I am a resident of the Central Coast Local Government Area and raise a strong objection to the proposed Kariong Sand and Soil Supplies Facility on environmental amenity and public interest grounds.

In this regard, please find the following contents of my submission which are required to be adequately addressed and resolved prior to the determination of application number SSD 8660 for any type of approval.

Figure 5 3-dimensional representation of topography surrounding project site

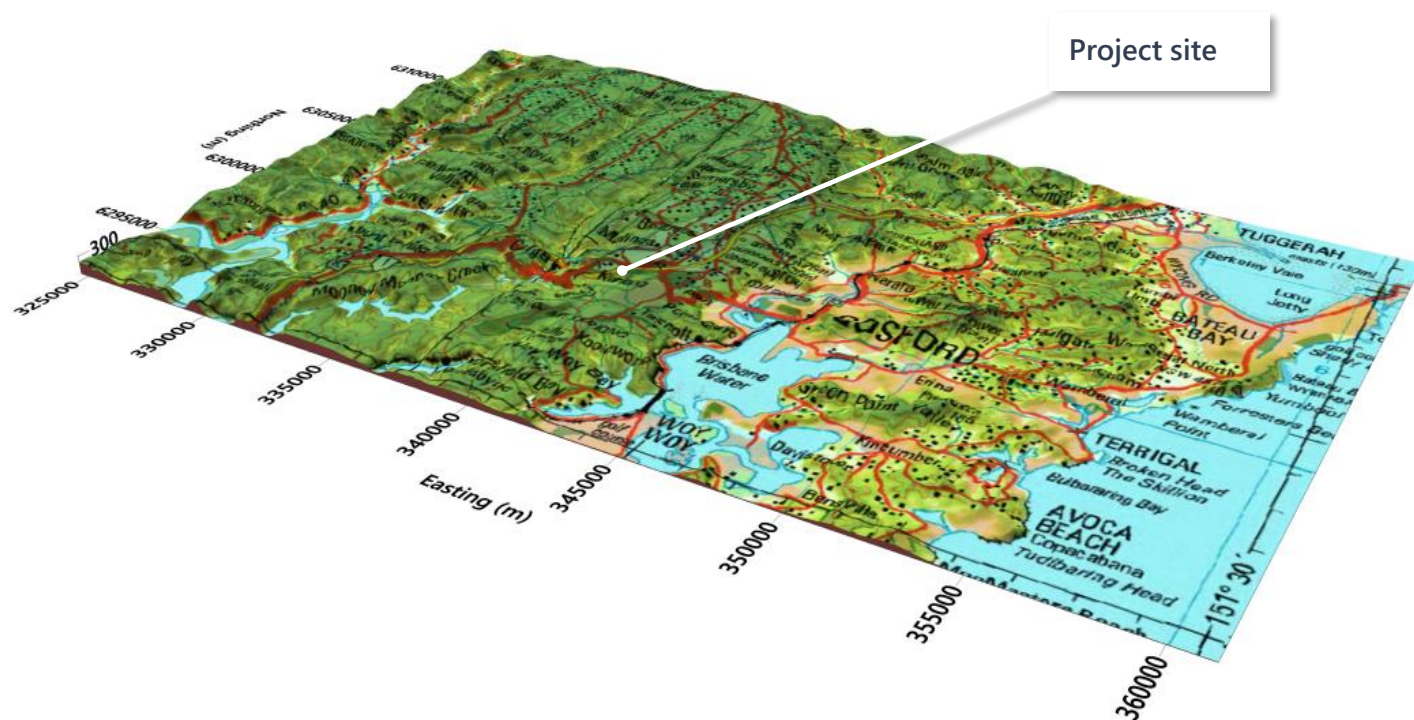
Section 4.3 – Topography, of the Air Quality Impact Assessment states the following:

“The wider area does contain more significant features as shown in Figure 5, although these would not impact significantly upon the transport and dispersion of pollutants between the project site and receptors.”

The applicant has provided no evidence to support the above statement that the local topography would not impact significantly upon the transport and dispersion of pollutants from the proposal to receptors. Including large scale assumptions like this as part of the study would again render the Air Quality Impact Assessment inadequate for use as part of the EIS.
